# ENG-PUDSP21005-R3-PUDSP.pdf Markup Summary

**Subject:** Callout  
**Page Index:** 1  
**Date:** 4/15/2022 3:10:03 PM  
**Author:** Ryan Howser  
**Color:** ■  
**Layer:**  
**Space:**  
**Page Label:** [1] WB PUDSP 3.10.22-Cover

SHEET NO.  
**10**  
10 OF 14 SHEETS  
FILE NO.  
**PUDSP215**

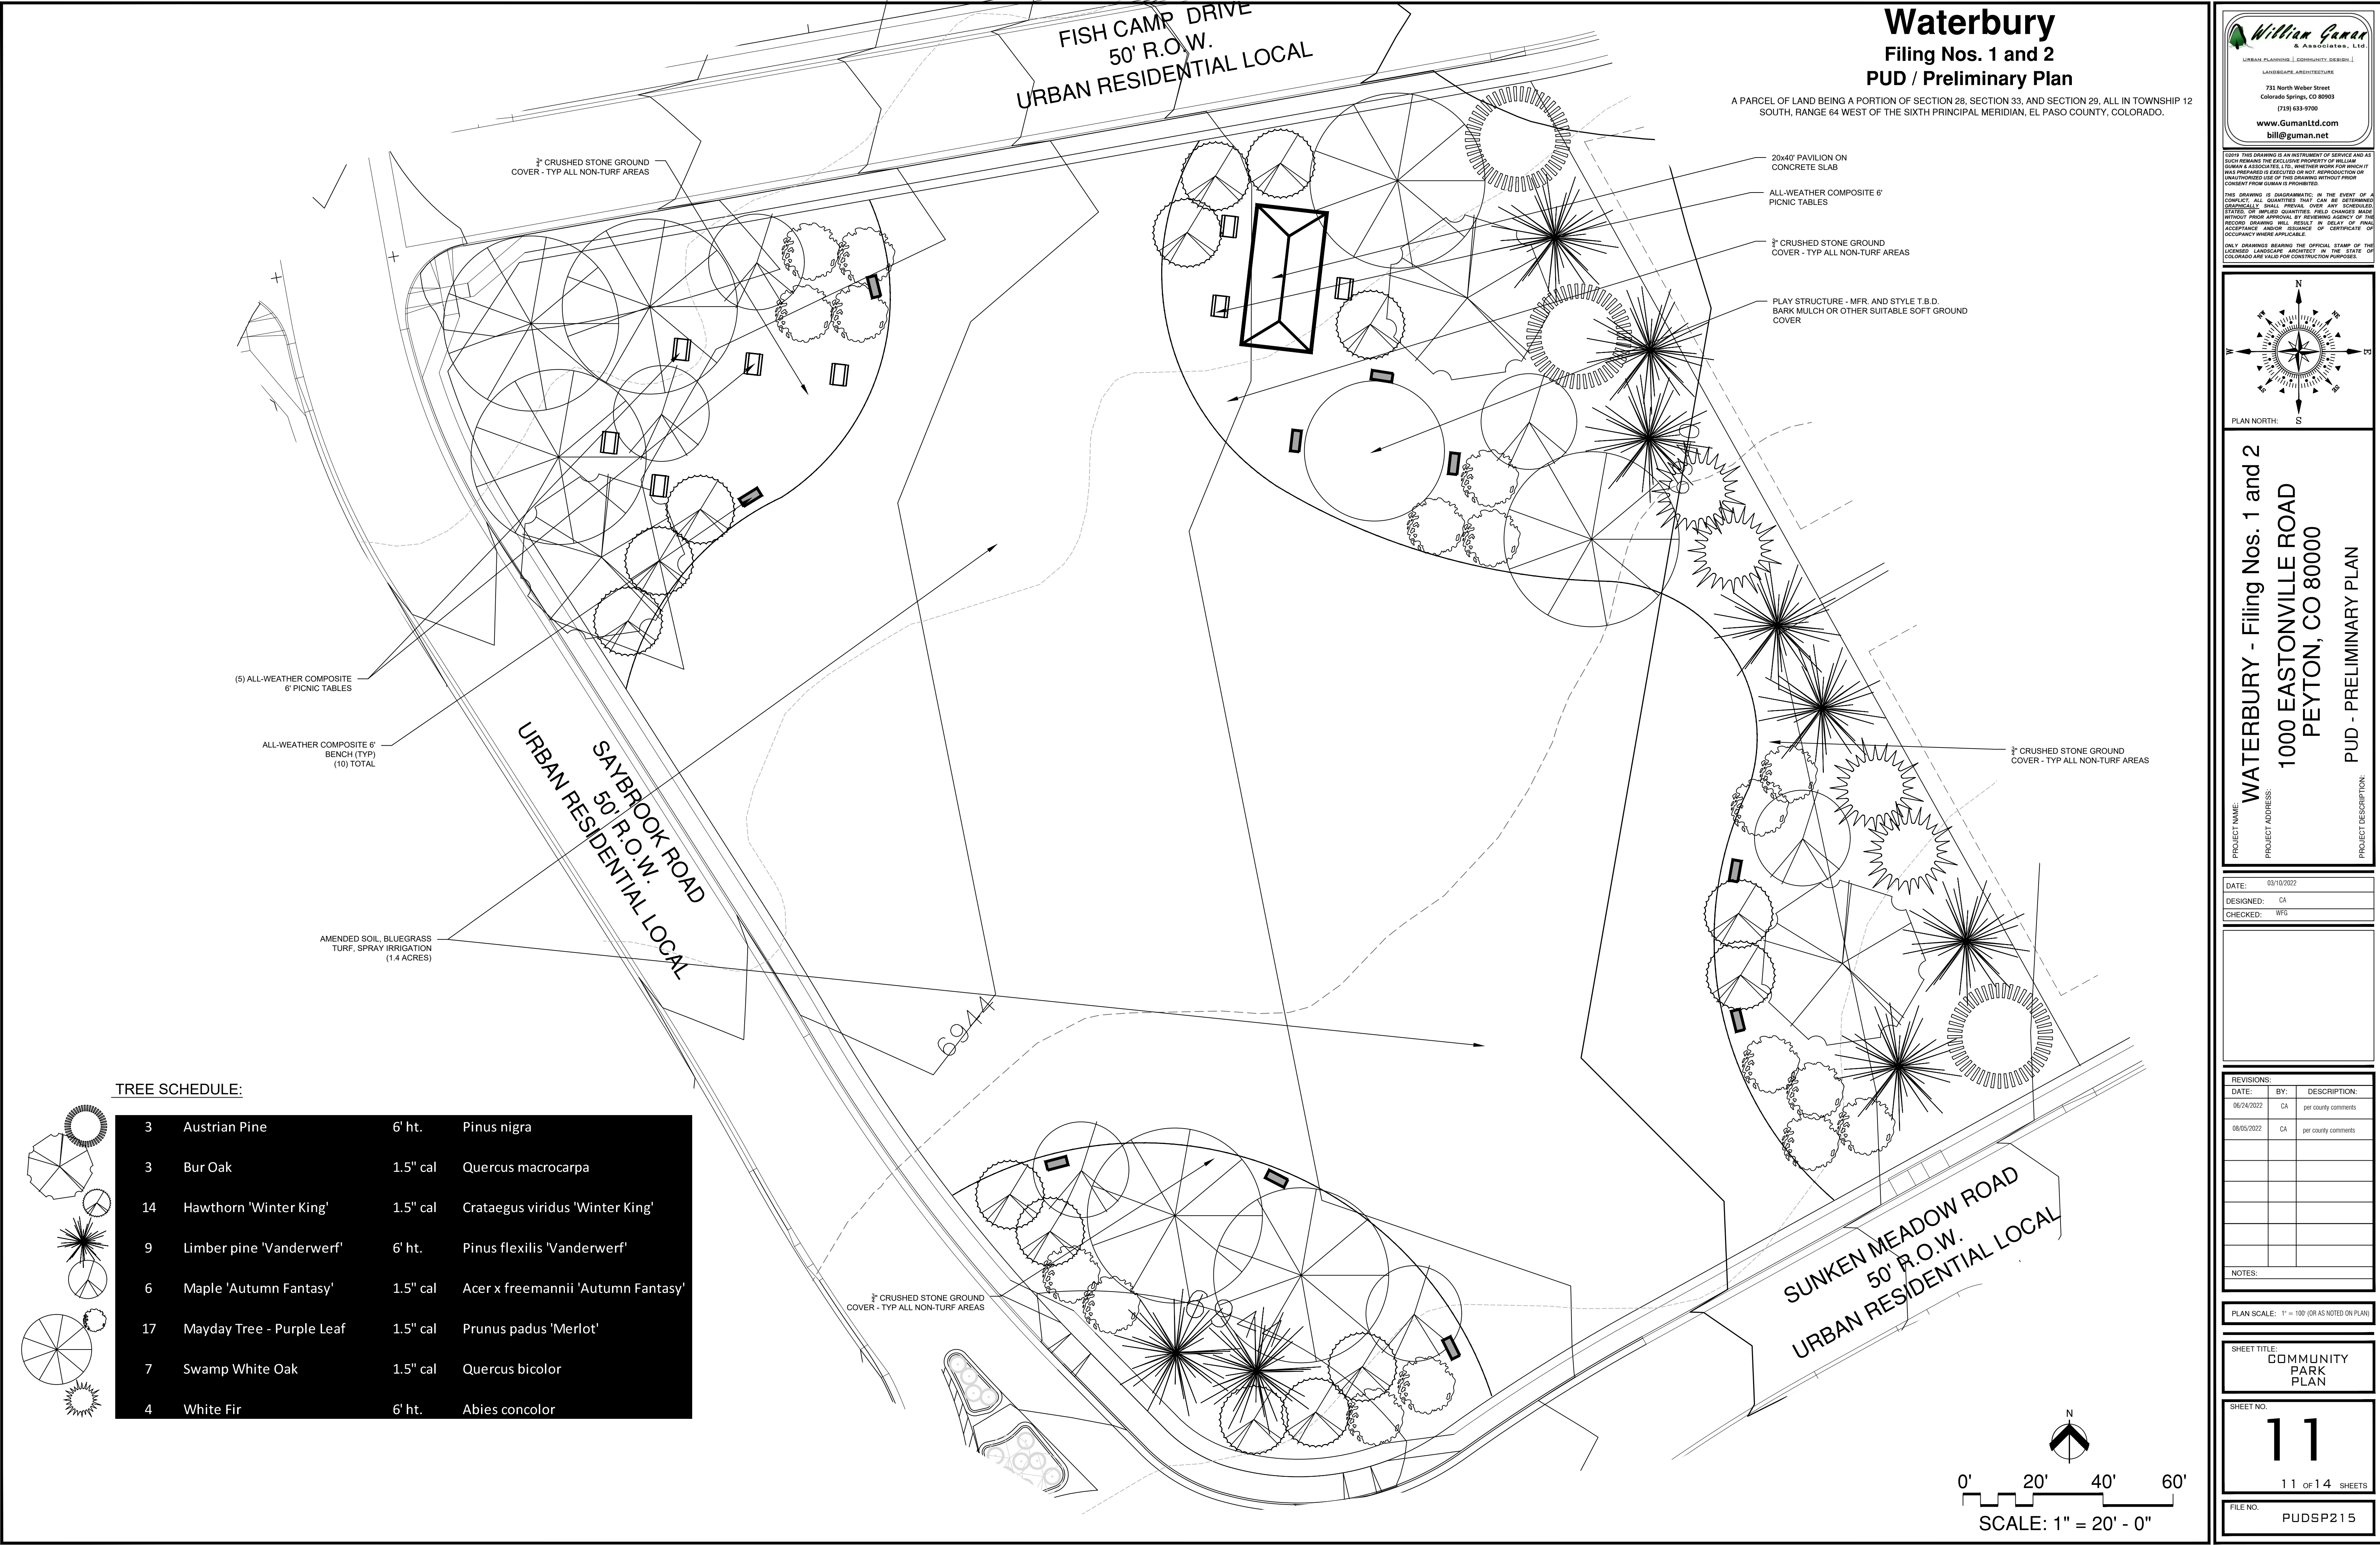
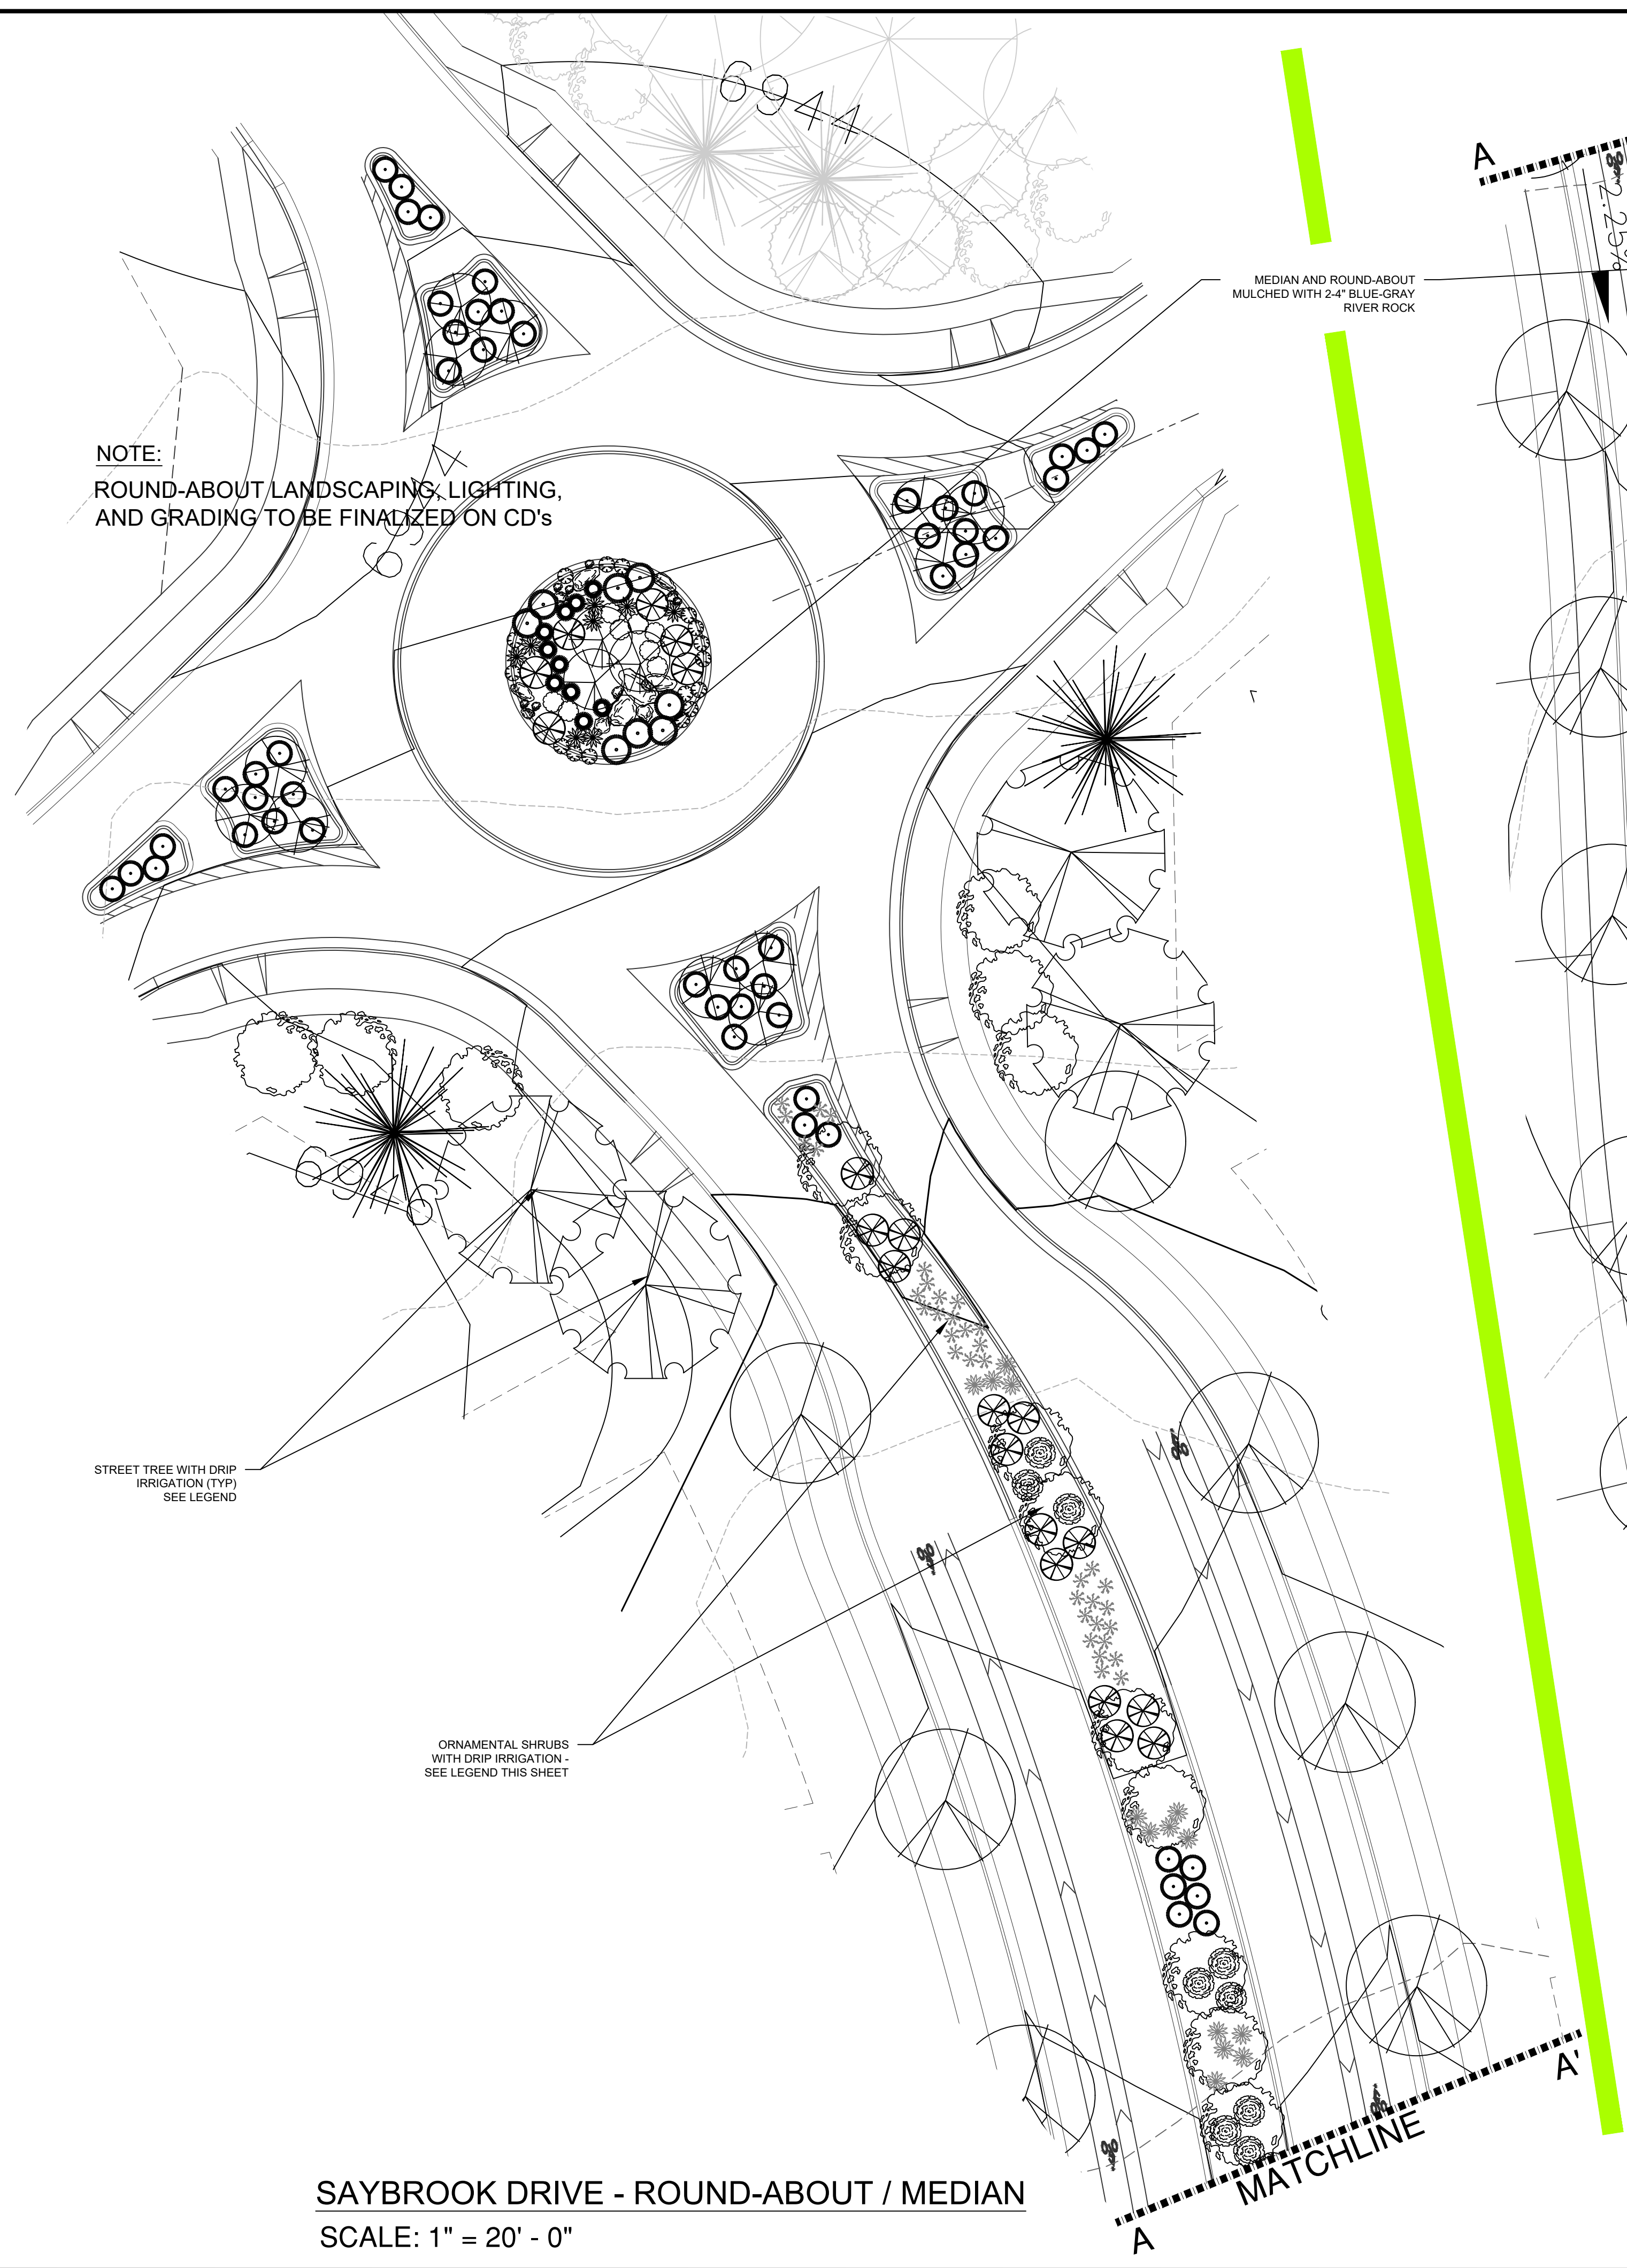
label interim pedestrian facilities

Show and label all areas required to be vegetated and maintained by the district for runoff reduction purposes. (Other sheets also)  
note on Sheet 3: Constraints - "Lots 35-42, 131-137, and 150-162 may not have any impervious improvements constructed within the rear setback (i.e. patios, hardscape, recreational facilities, etc.), and shall route downspouts across pervious areas, incorporating vegetation in areas that generate and convey runoff using non-hardened drainage conveyances such as pervious side yard swales to direct runoff offsite. One key BMP includes the use of grass buffers and encouraging the planting of grass in these rear yards."

Show the wetland hatching

note added

added and labeled

Also noted in General notes and on relevant pages is that the MD will maintain vegetation in all tracts associated with runoff

SHEET TITLE:  
**PLANTING  
PLAN  
SAYBROOK**

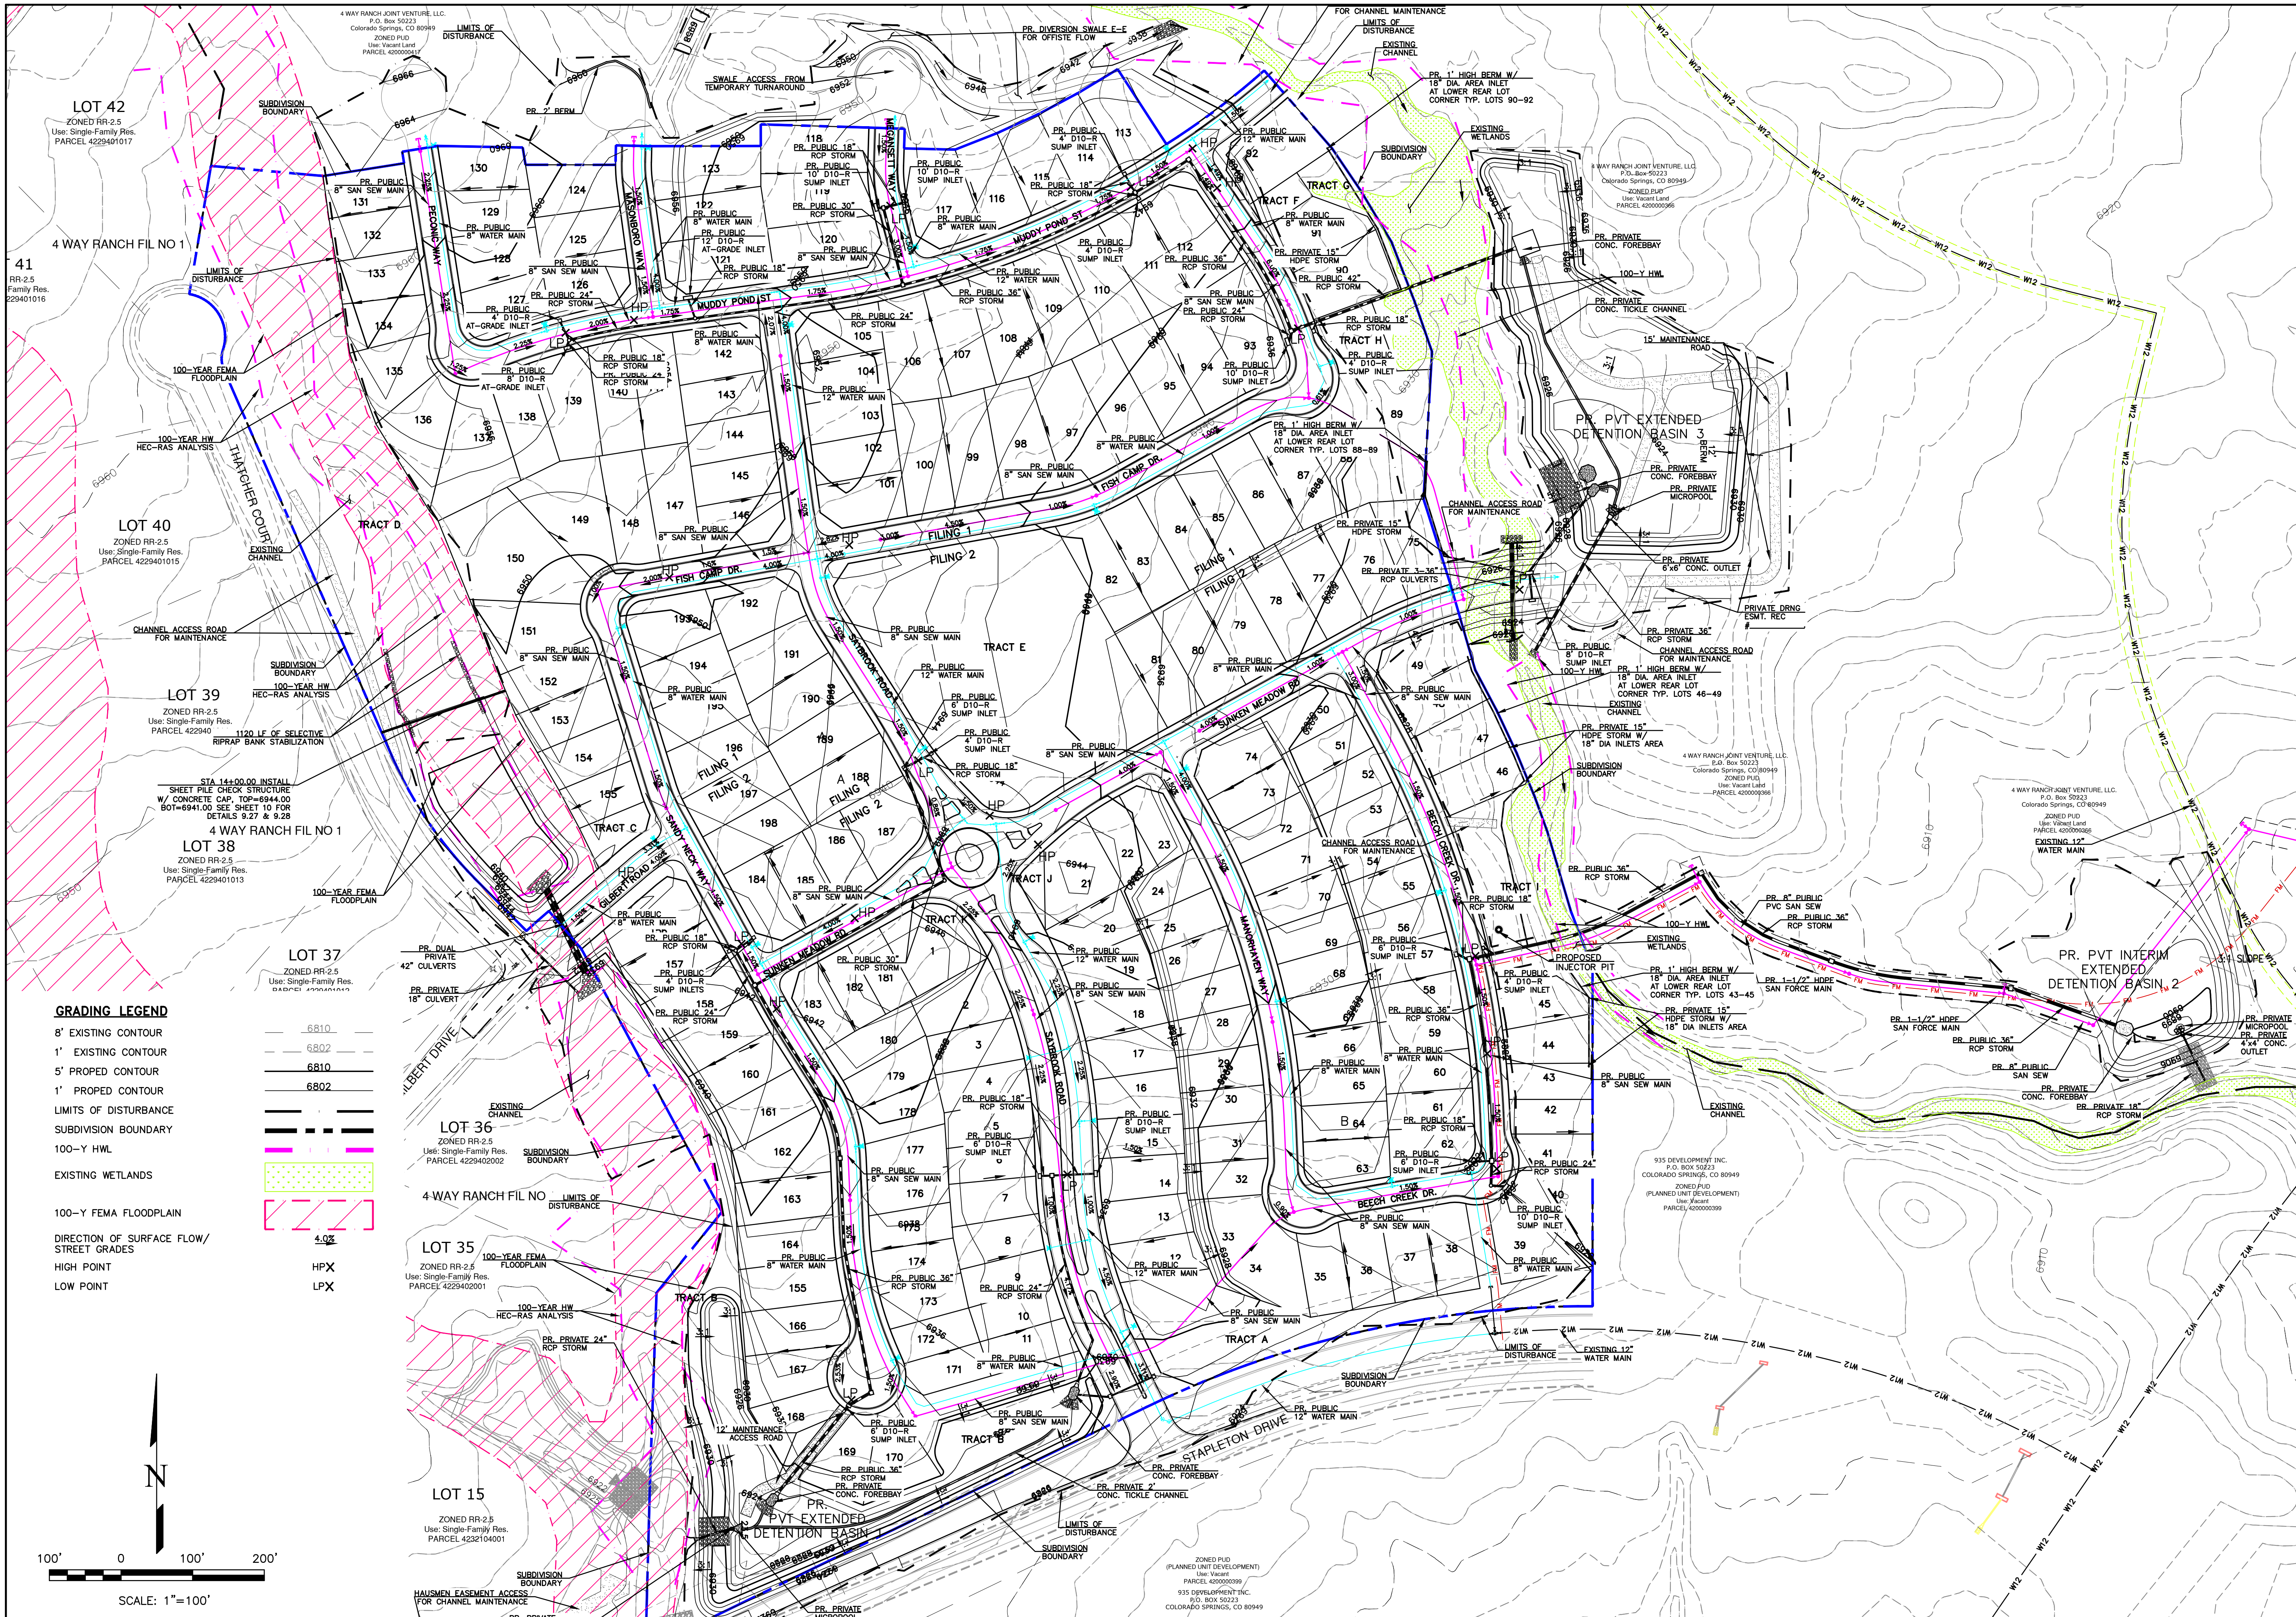
Add a note stating that roundabout lighting, landscaping and grading will be finalized with CDs

note added
